Application No: BE/163/21/PL
Site Address: 22 Osprey Gardens Bersted PO22 9QG
Description of works: Erection of 1 No. dwelling. This site is in CIL Zone 4 and is CIL Liable as a new dwelling.

OBJECT as follows,

existing block plan

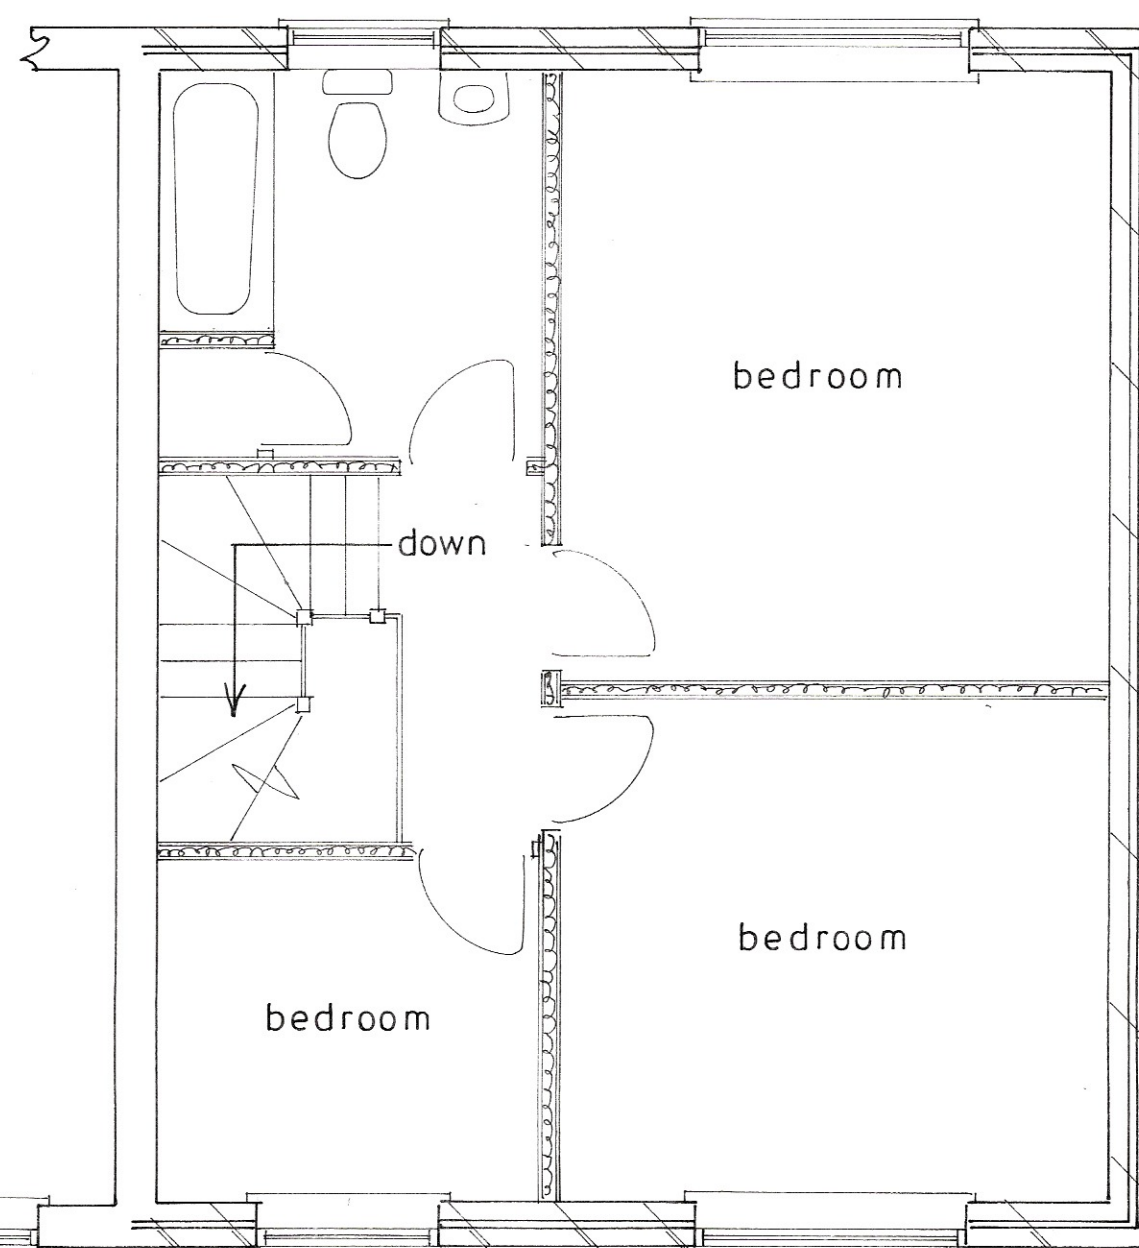
The proposed application is an overdevelopment, contrary to Arun Local Plan Policies D SP1. Does not provide enough parking for the new development or the existing property, contrary to Bersted Neighbourhood Development Plan policy HDQ8 for 2 spaces per dwelling.
